Application No: AW/240/20/PL
Site Address: 17 Nyewood Lane Aldwick PO21 2QB
Description of works: Change of use of former residential parenting unit (C2 Residential Institution) to 8 bed House in Multiple Occupation (C4 Sui Generis). This site is in CIL Zone 4 (Zero Rated) as other development.

Thank you for your internet representation made on 28th October 2020 which has been recorded as an objection with the comments as follows:

Plan Produced for: CHANGE OF USE APPLICATION

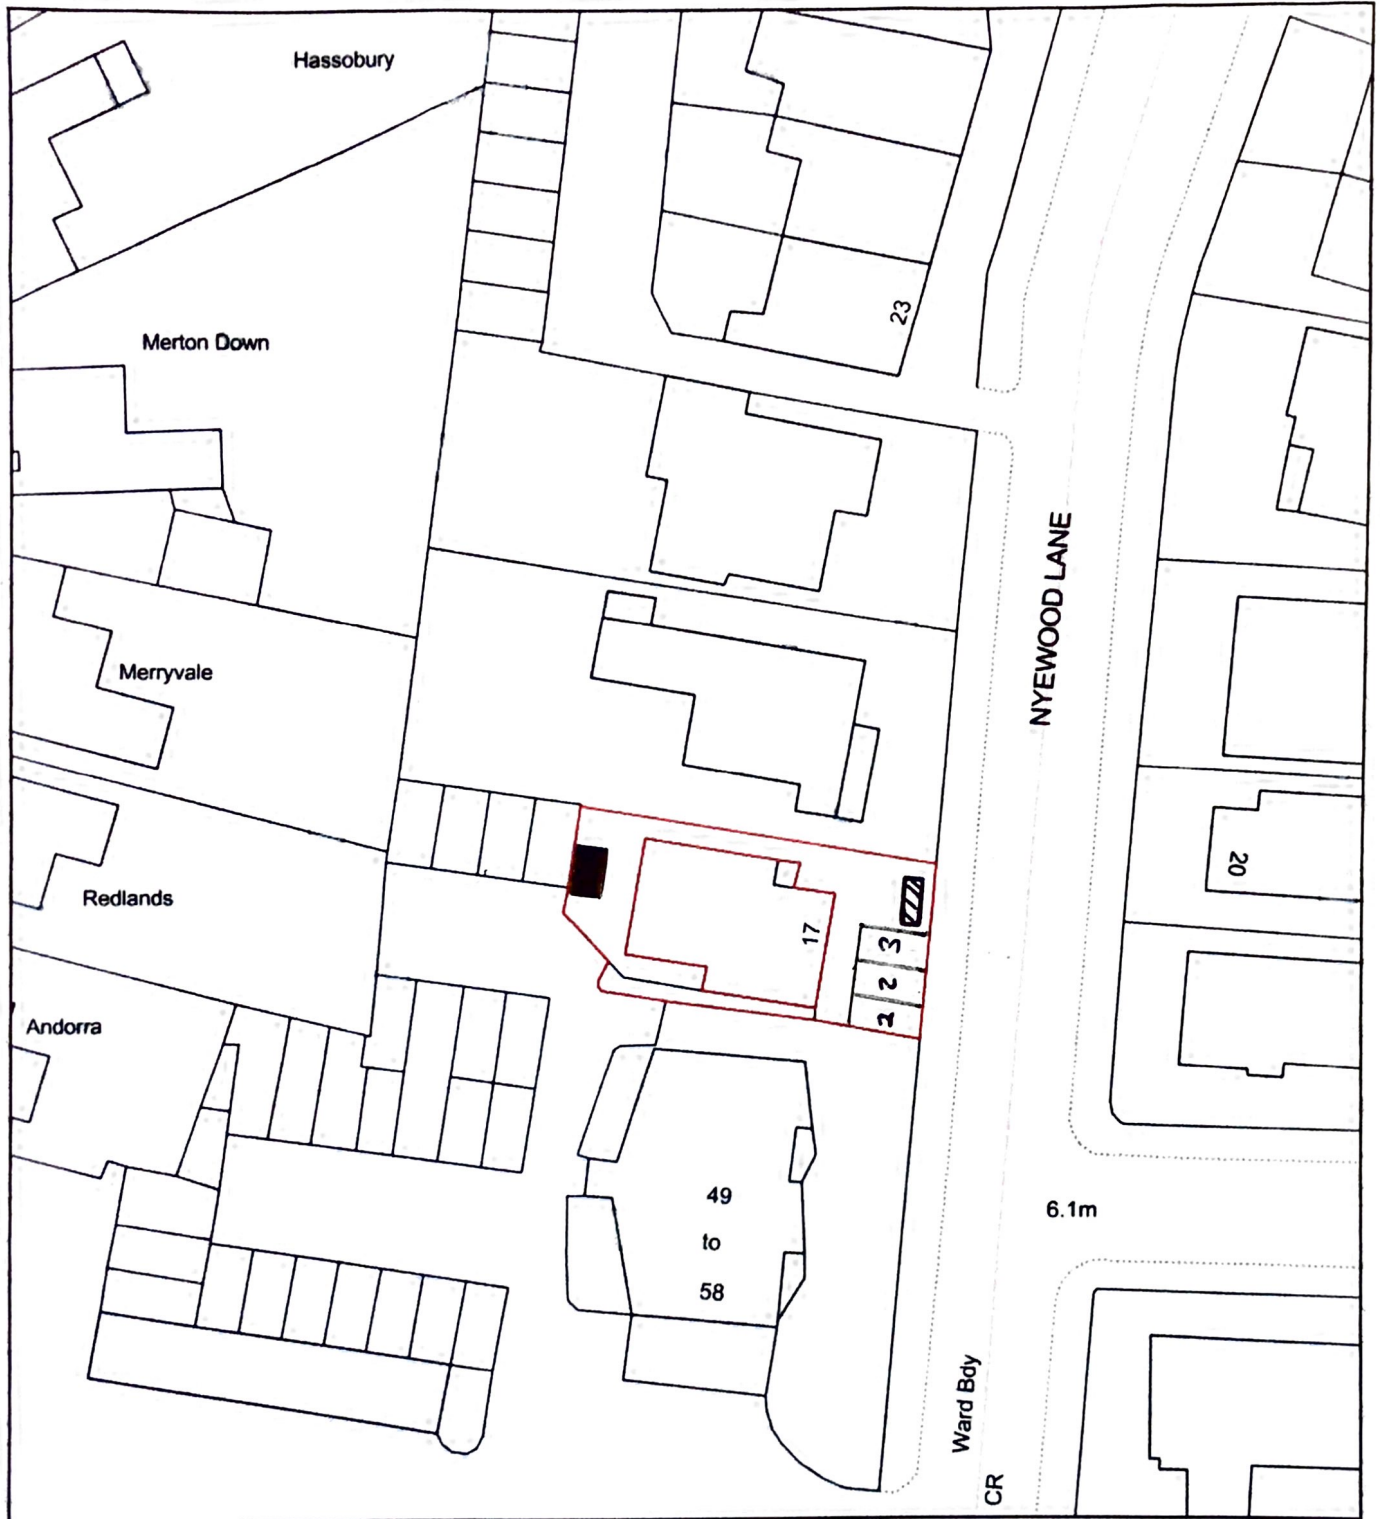
Owing to the rudimentary nature of the plans, it is difficult to ascertain whether this is a "shared house" or a "bedsit-type shared house" for which different licences are required. Although all rooms appear to meet the size criteria for double occupancy, Members found no indication of whether the rooms are single or double in nature and therefore the number of occupants remains unknowable. Furthermore, the rudimentary plans make it impossible accurately to gauge the dimensions of the rooms rather than the overall area. Members noted that the kitchen diner meets criteria for up to 12 persons but should the intention be to classify the bedrooms as doubles, the size would be inadequate. Members also found confusing the labelling of one room as a kitchen diner and another as a dining room. While commending the ensuite bedrooms, Members considered that, apart from these, the first floor appears to have the only shower room and the ground floor has one toilet in the utility room for 2 bedrooms and an unknown number of occupants as well as eating and dining facilities. Members noted that there is no comment from environmental health/private sector housing department concerning adequacy of facilities nor is there a recommendation from the fire authority regarding their requirements to meet legislative standards. Nyewood Lane at this point is a mixture of houses and flats with a balance of both to maintain the nature and character of the area. A further house of multiple occupancy would upset this balance which is already threatened because of other proposed developments. This building occupies a sensitive site because of the proximity to the sea and local parks, a restaurant, a busy public house and local nursing homes and shops. Parking requirements are not just for residents, but for visitors to the town. The application states that parking spaces have been reduced to three (marked 2, 2 and 3 on the plan) although there is a missed opportunity for the provision of an electric charging point. (Arun District Parking Standards Supplementary Planning Document 2020) The committee noted that this number of

dwelling would put further demand on scarce parking in this area. Therefore, members strongly opposed the application on the grounds that the change of use would be detrimental to the amenities of adjoining properties and would give rise to material change in the character of the neighbourhood properties and therefore would contravene Policy H SP4 (a) and (b) and that the development would contribute to the generation of excessive parking demands harming nearby public amenities and contravening Policy H SP4 (c) both of the Arun District Local Plan 2011-2031 and Parking Standards Supplementary Planning Document January 2020. Members further considered that insufficient information was given regarding the precise sizes of rooms and the safety facilities required to meet national standards (Policy D DM2). They were also concerned at the apparent inadequacy of hygiene facilities. Members regret the missed opportunity to provide further visitor accommodation for the town's tourist industry or high quality single dwelling accommodation fit for the future.
